DECISION DELEGATED TO HEAD OF PLANNING

Application No: H17-0983-24 **Applicant:** Mrs J Pola

Proposal: Residential Development - Single Dwelling - 0.037Ha and change of use of part Agricultural field to Site for Biodiversity Measures. 0.038Ha

Location: Adj 80 Seas End Road Surfleet Spalding

SITE PLAN - PROPOSED 1:200

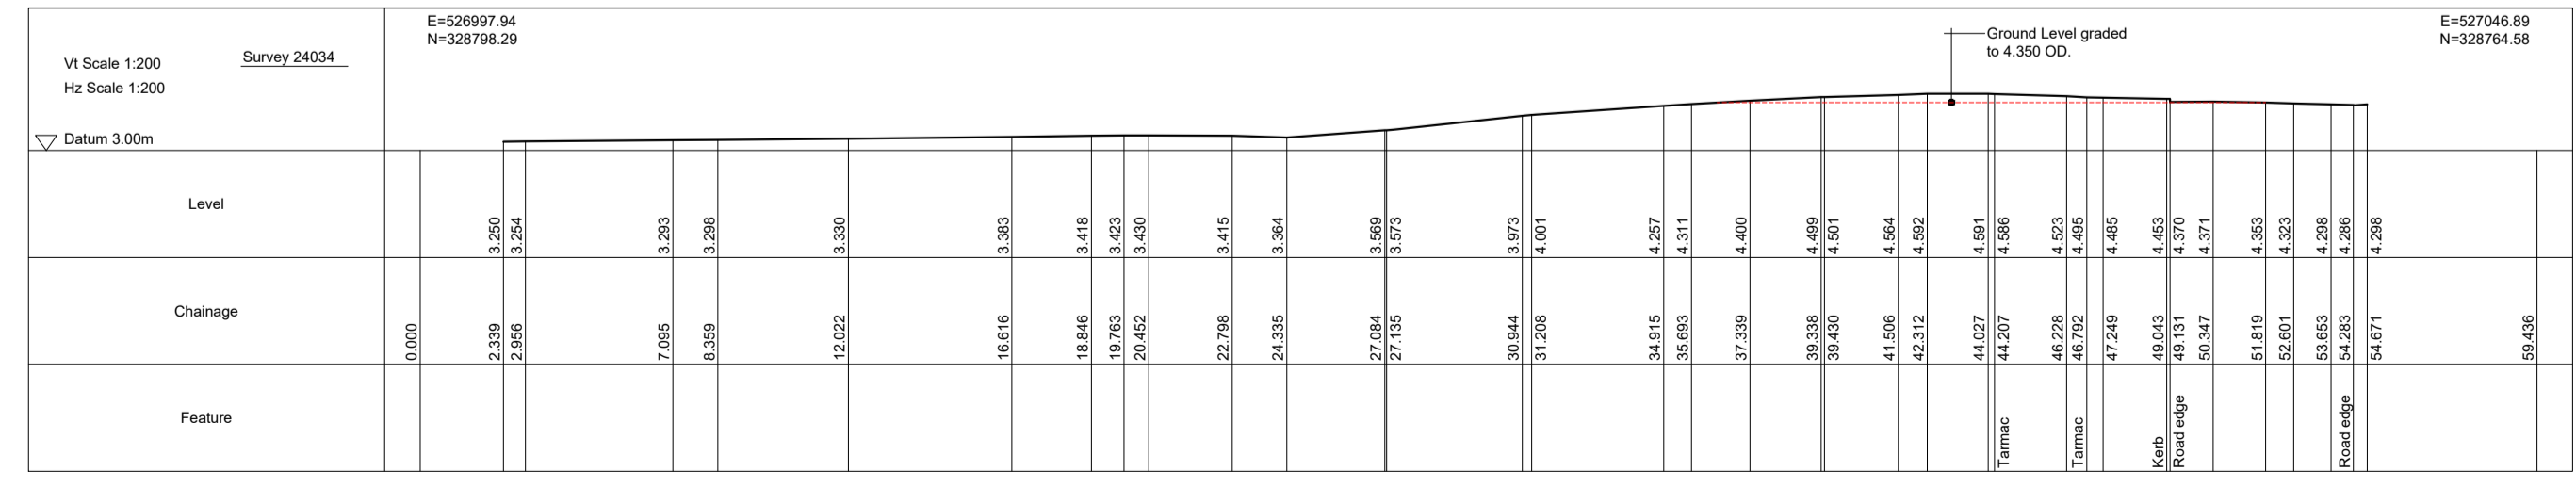
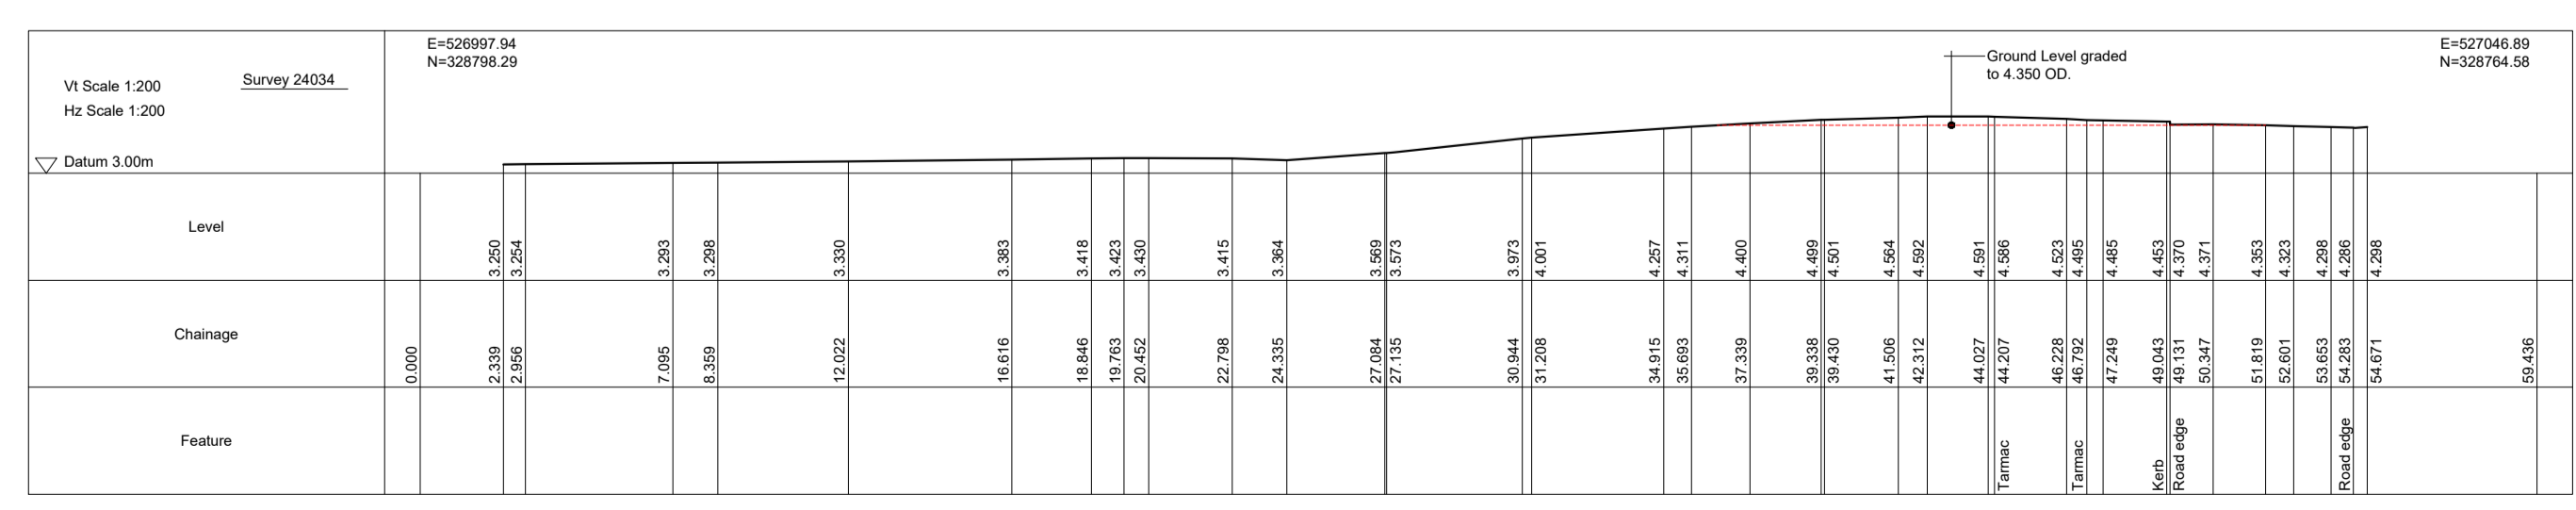
However, it is noted that there is a proposed site plan that has been submitted, the plans does not show the potential development, however it does show the size of the plot, in respect of the scale of the application site and feasibility to site a dwelling, showing it would relate well within the setting as it is a clear infill plot.
